KITTITAS COUNTY DEPARTMENT OF PUBLIC WORKS

TO: Chelsea Benner, Planner I
COPY: Taylor Gustafson, Planner III
DATE: October 19, 2018
FROM: Mark R. Cook, Director 
RE: SD-18-00001 Williams

Public Works has the following comments on the Williams substantial shoreline development permit application:

PRE-CAST CONCRETE FOOTINGS DRAWING 8

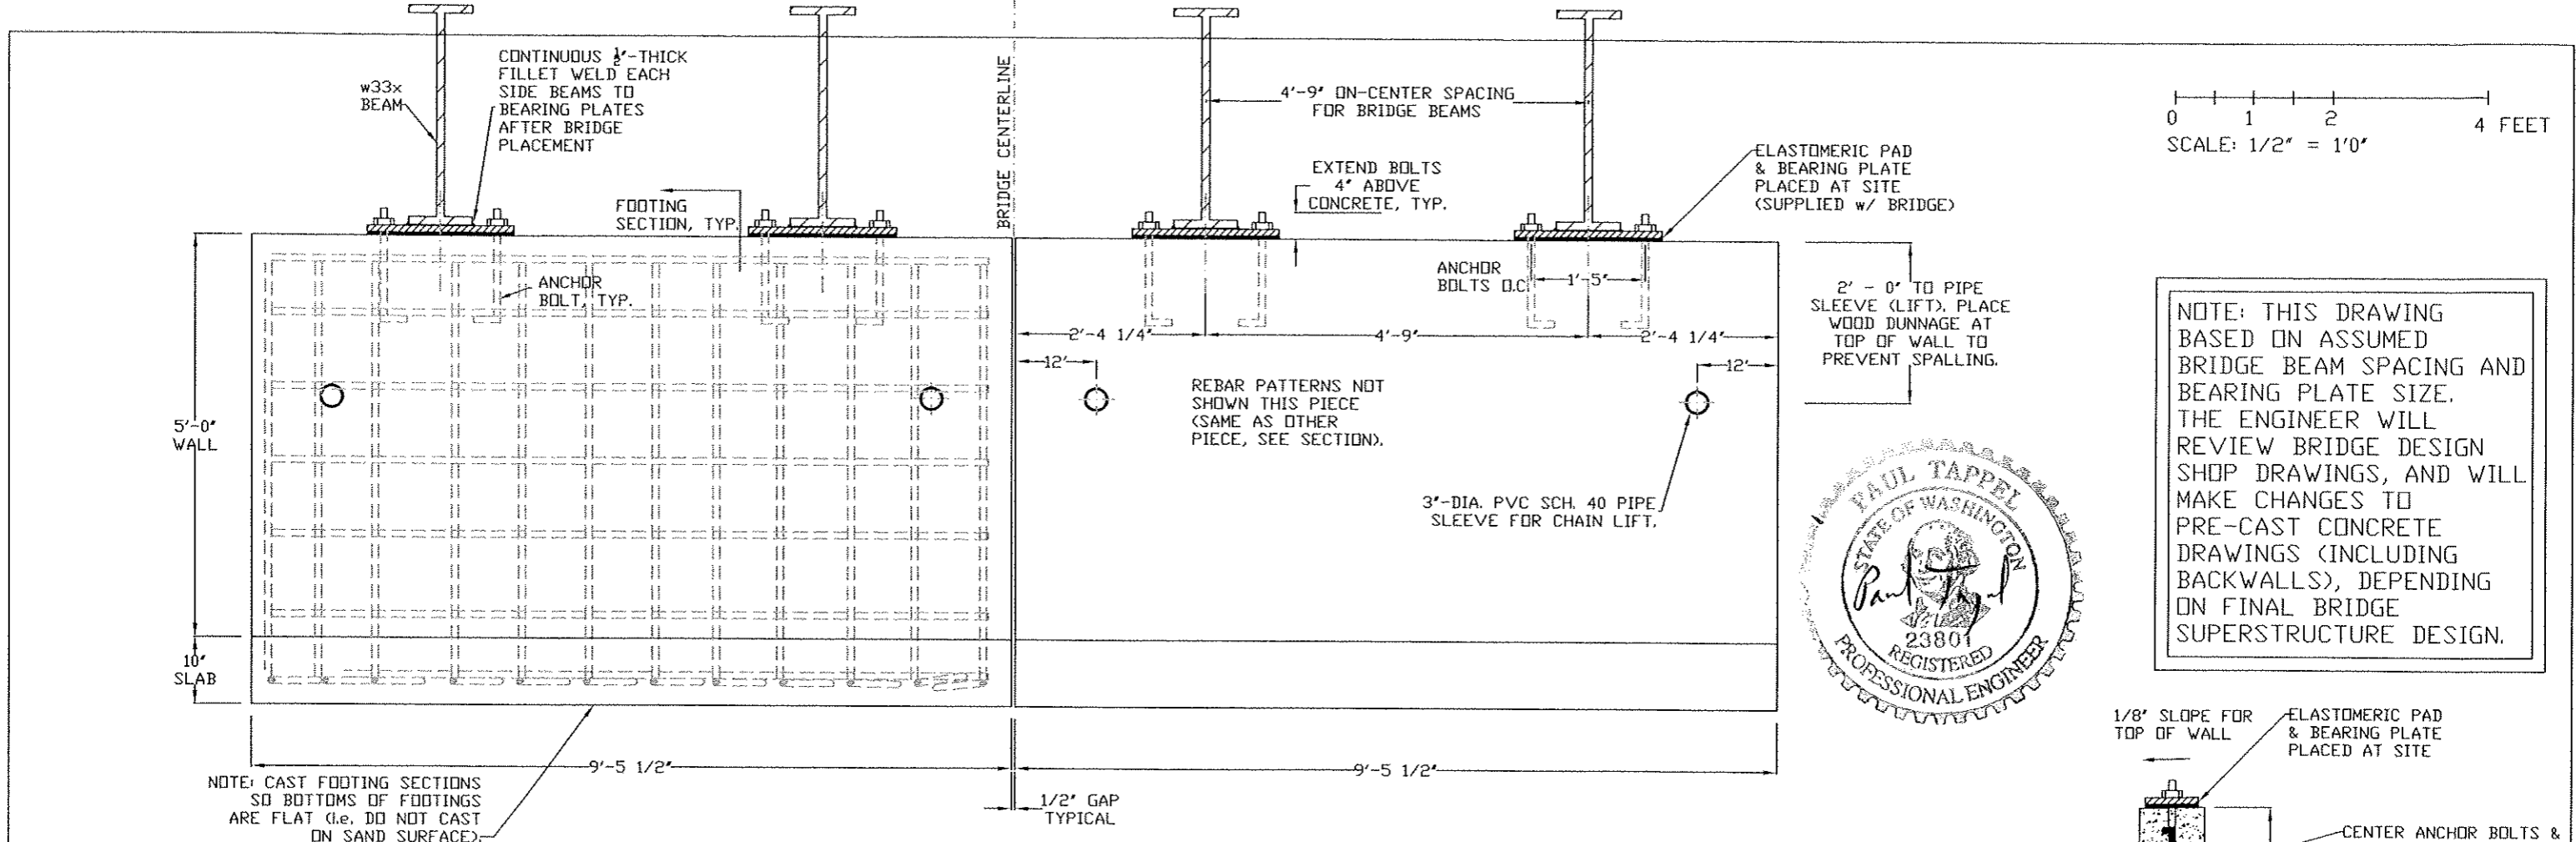
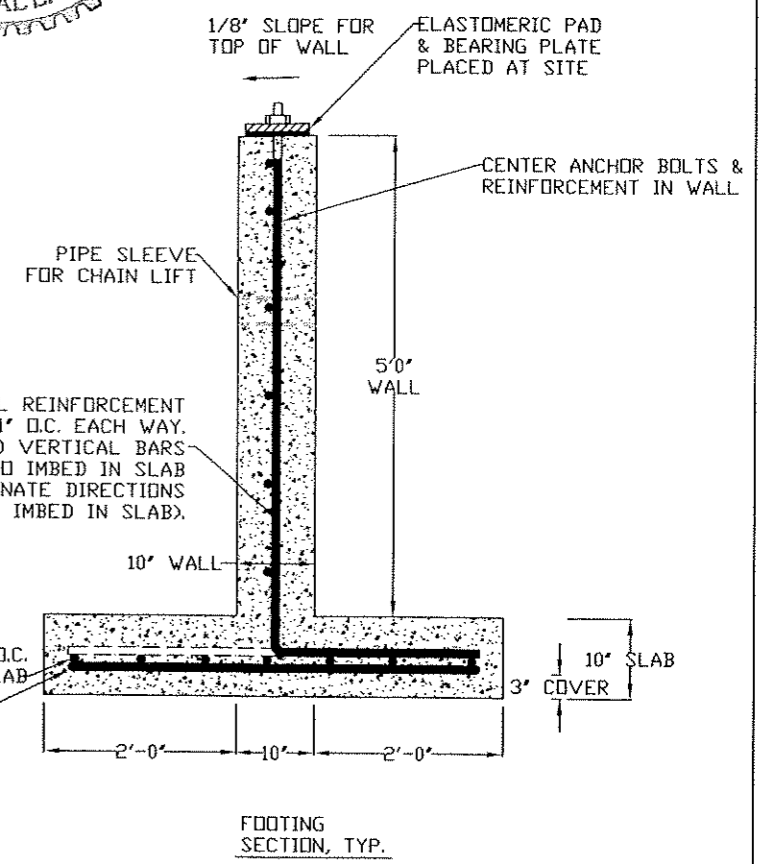
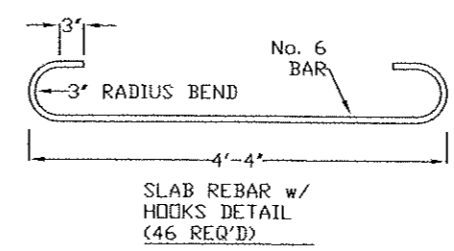
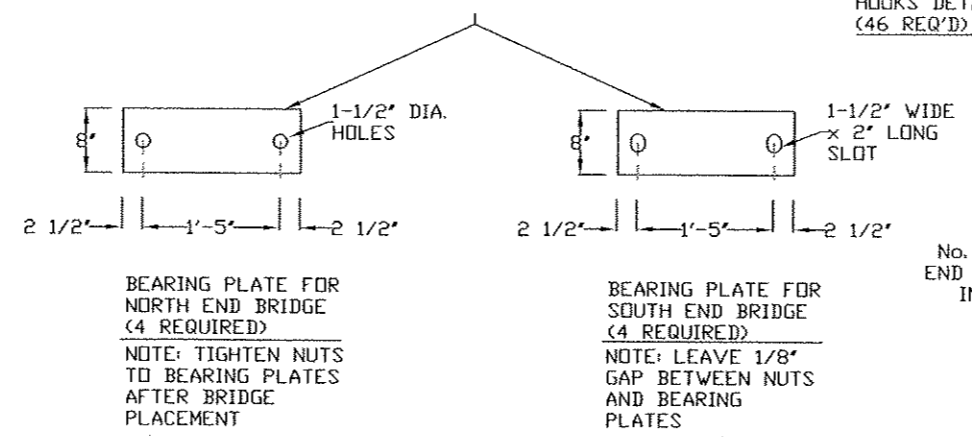
1. The bridge specifications provide no engineering calculations. Prior to bridge design approval, supporting calculations and a load rating are required.
2. We do not see anywhere in the application the type, quantity, source and composition of driveway and bridge approach abutment fill is detailed.
3. We note that a 100 year flow volume is referenced but there are no supporting calculations. The flow volume is a necessary component of validating bridge freeboard.
4. The application materials do not identify the access location for the proposed new driveway. It is unclear if the proposed new access location has any implications to floodplain or shoreline.
